**RE: Honey Well – Docks and Parking Lot
Conceptual Grading and Drainage Plans
Engineer's Stamp Date: 06/18/24
Hydrology File: B17D001B**

Based upon the information provided in your submittal received 06/19/2024, the Conceptual Grading & Drainage Plans are preliminary approved for action by the Development Facilitation Team (DFT) on Site Plan for Building Permit.

**RE: Honeywell
9201 San Mateo Blvd.
HONEYWELL- DOCKS AND PARKING LOT GRADING AND DRAINAGE PLANS
HYDROLOGY FILE: B17D001B- RESPONSE TO COMMENT**

DOCK G DETAIL

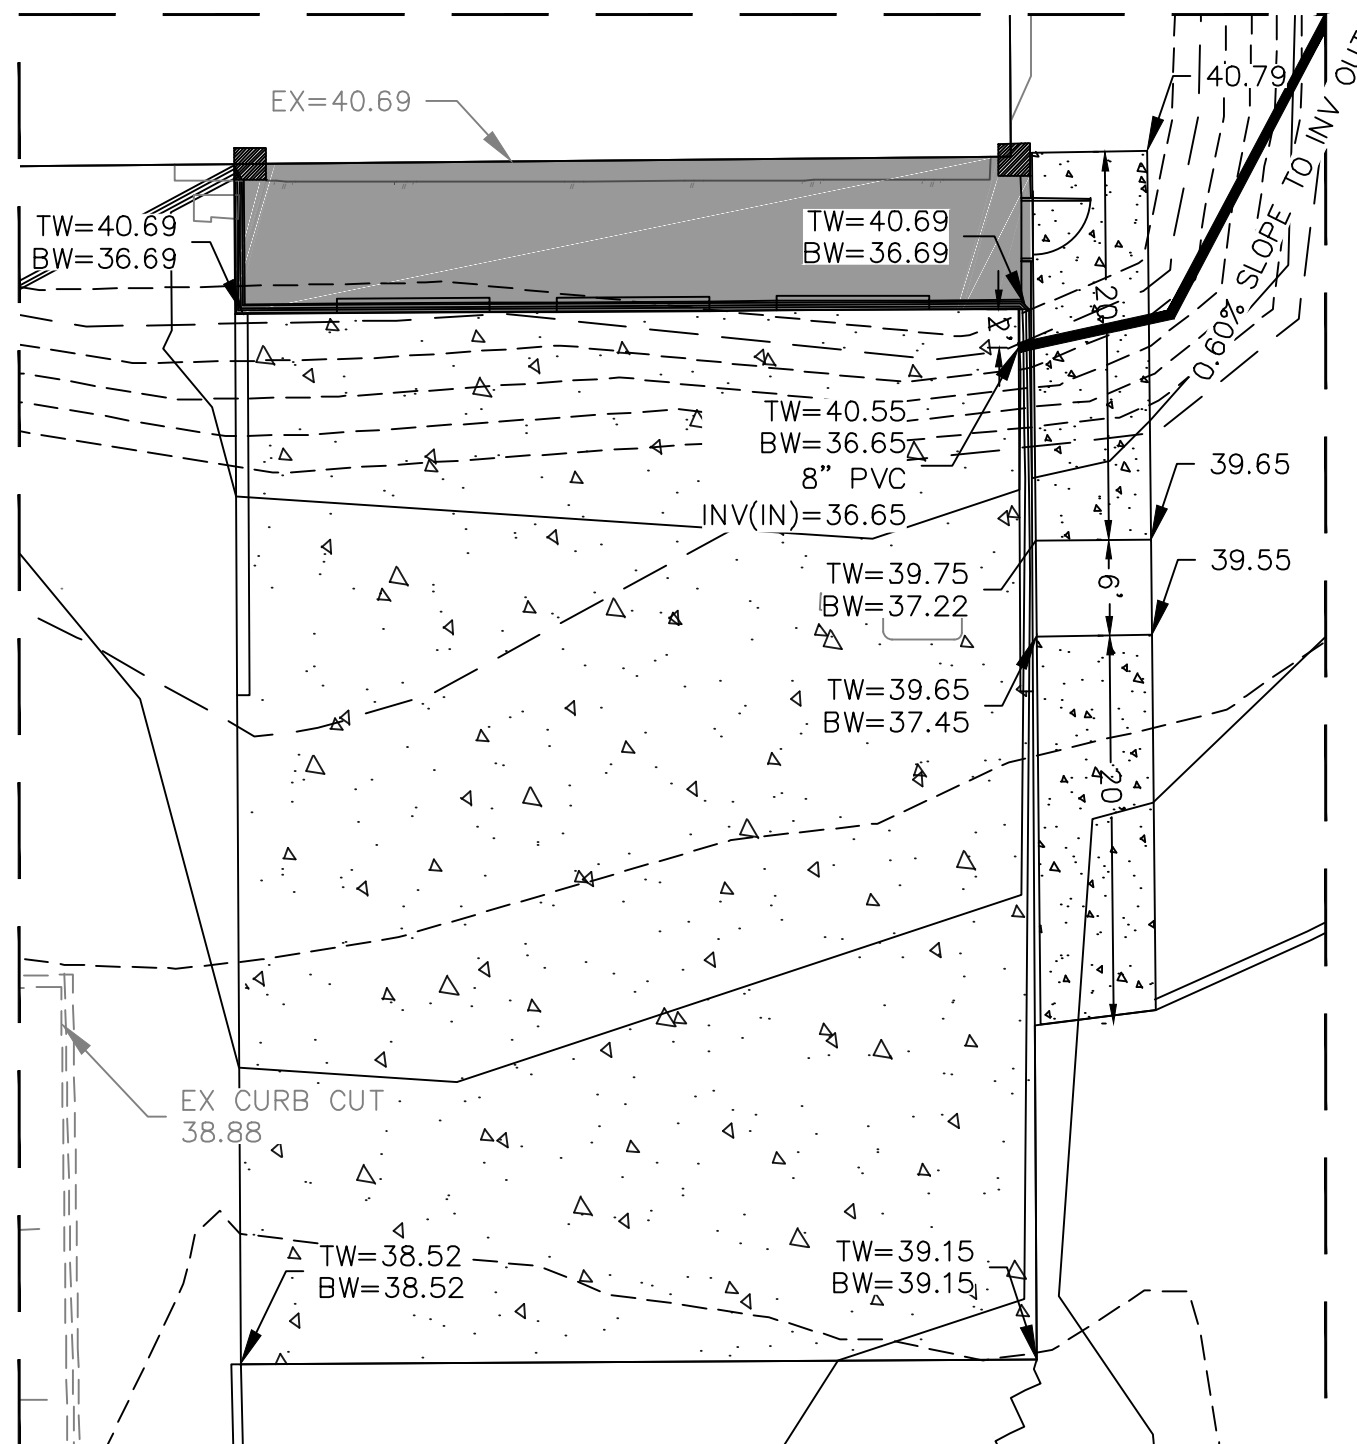
29. **Comment:** Again, it is hard to tell what is being constructed here. The proposed pavement disappears in all of the other line work.

Response: Cleaned up sheet to show what is being designed better.

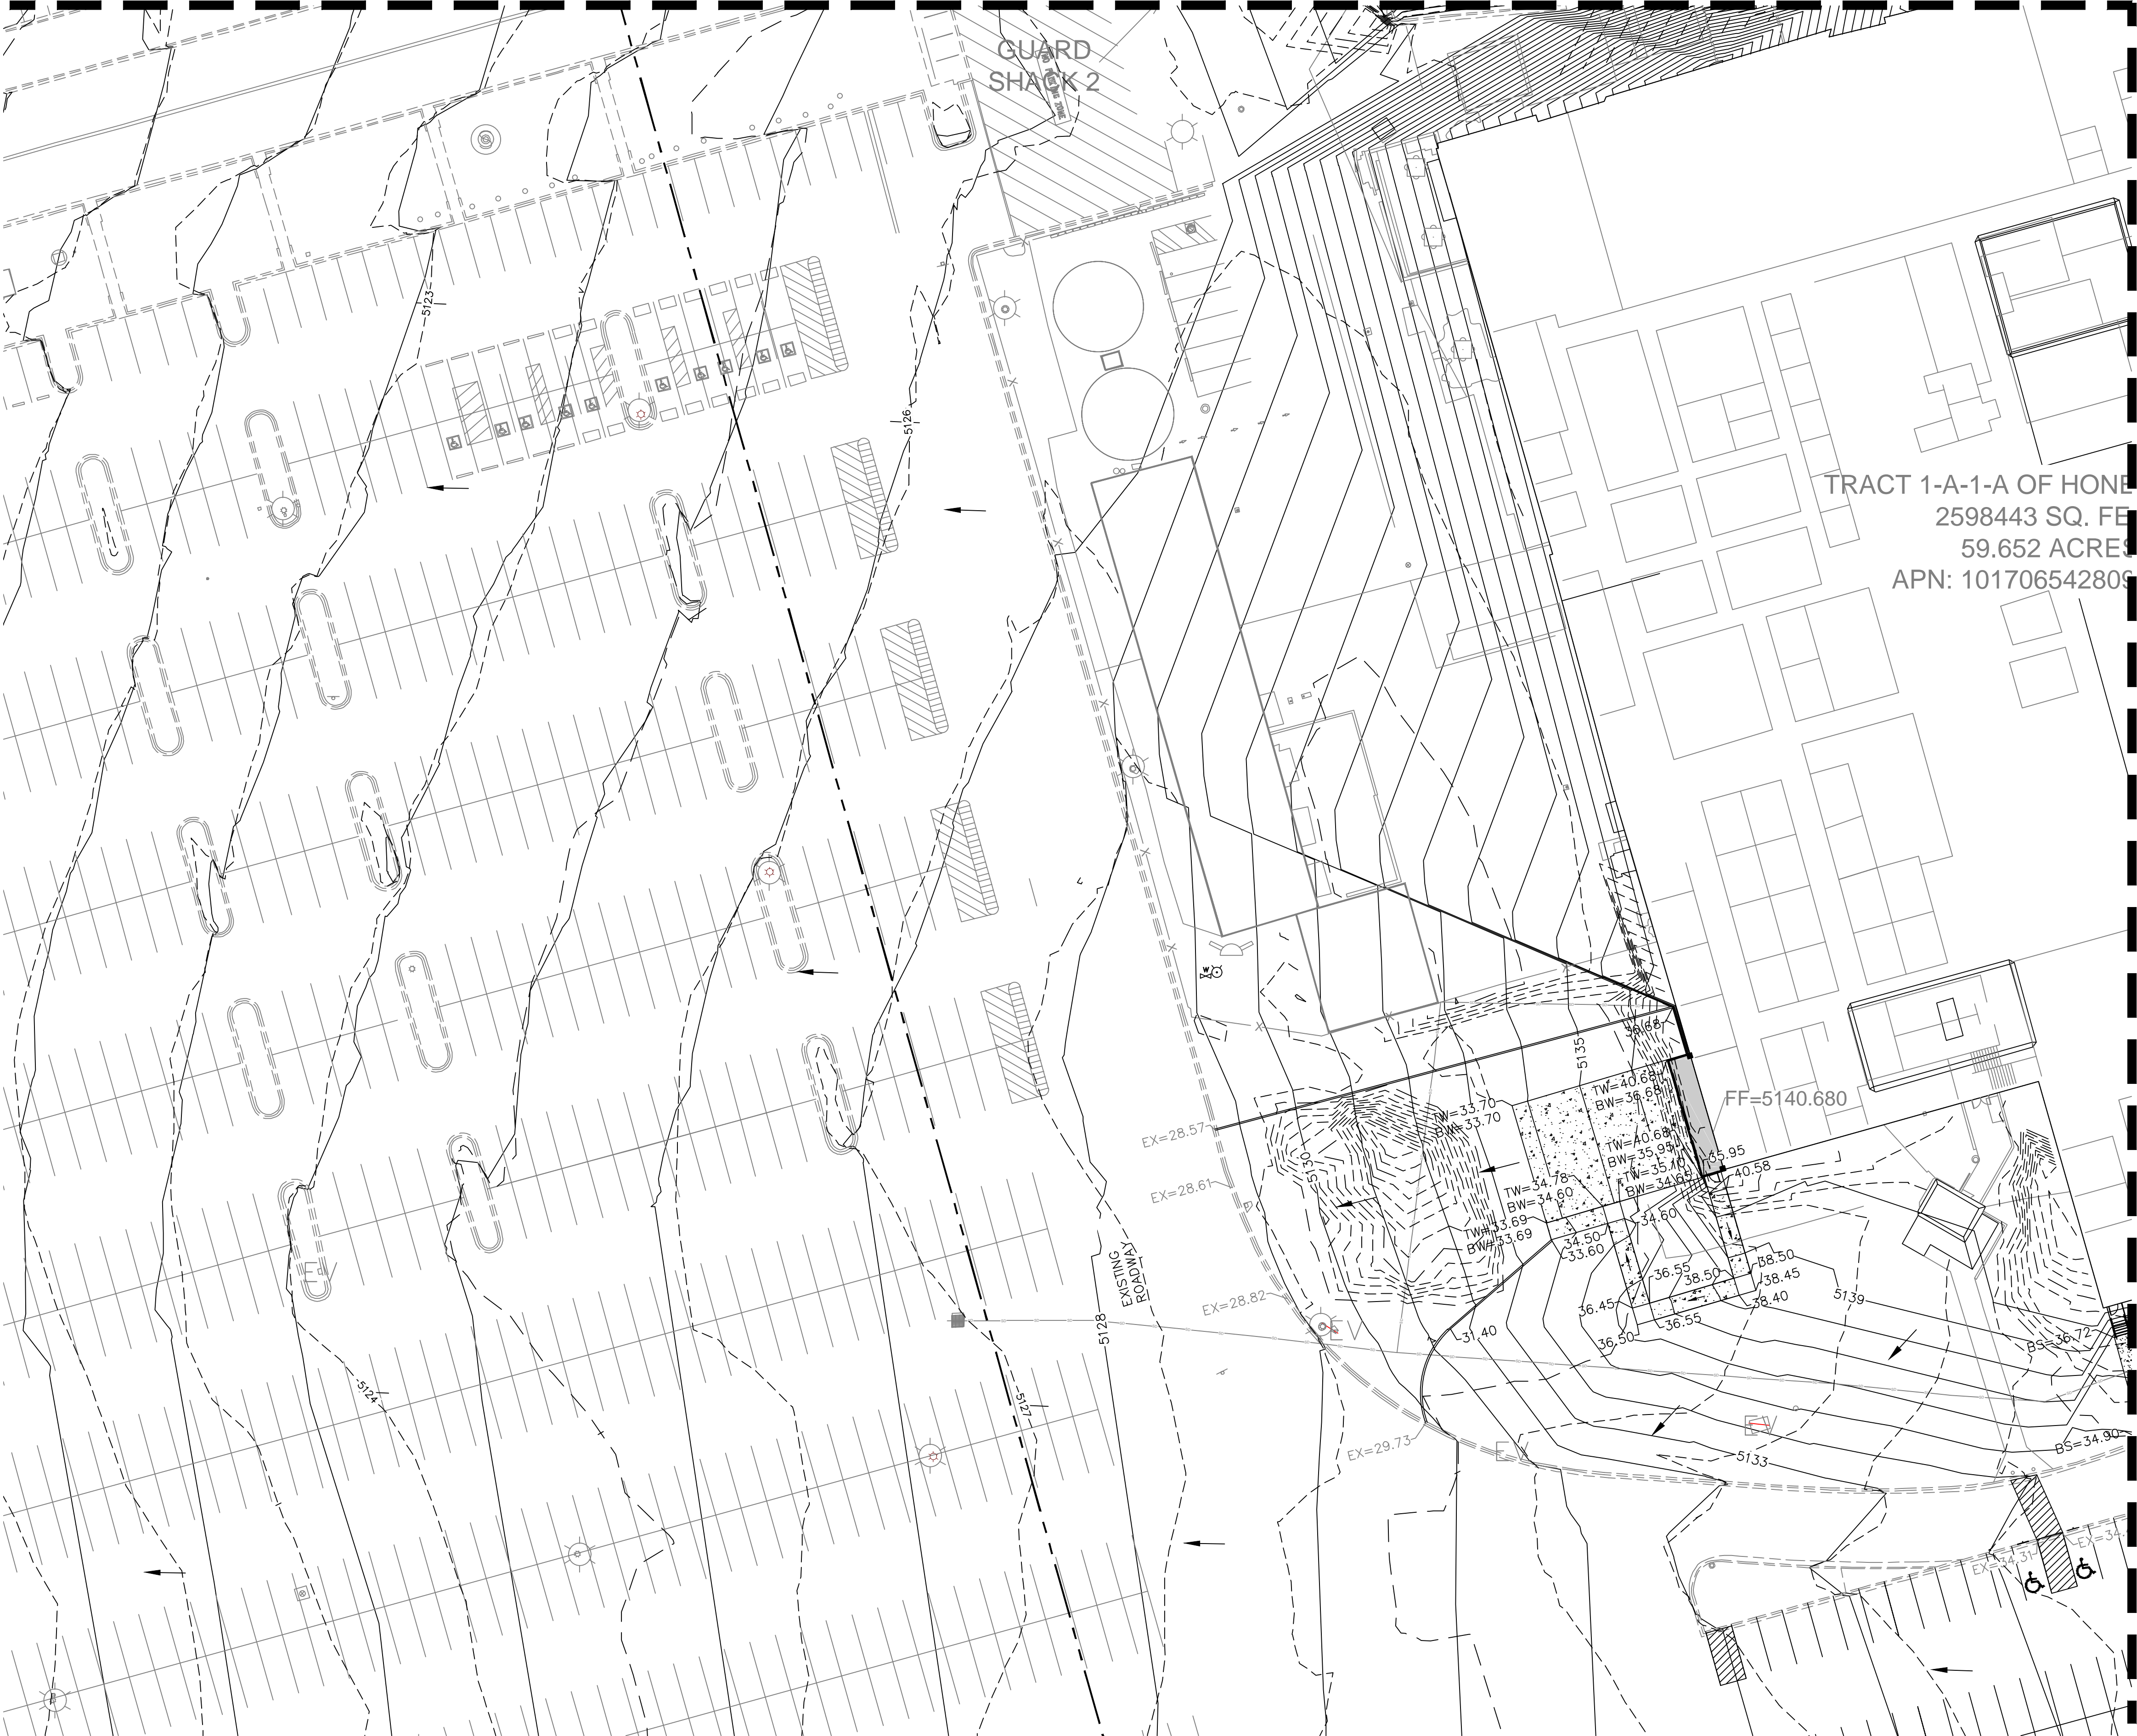
26. **Comment:** Please clean up the proposed dock areas. There should be no proposed elevations here. All proposed elevations need to be shown on the blow-up Detail of the dock.

30. **Comment:** The last dock appears to have not been designed correctly for a truck to back into. Please review this.

31. **Comment:** Please revisit the required retention pond design. I think that this could be designed a little bit better but please keep in mind to keep a side slope of 3:1 or provide a retaining wall if need be.

Response: All proposed dock areas were cleaned up and shown as a low-up Detail on sheet C2.7.

Response: The dock design was accepted by our client.

Response: The ponding was stretched south to reduce the depth from 8' to 5'. All sloping at the pond and to the pond is at 3:1 sloping.
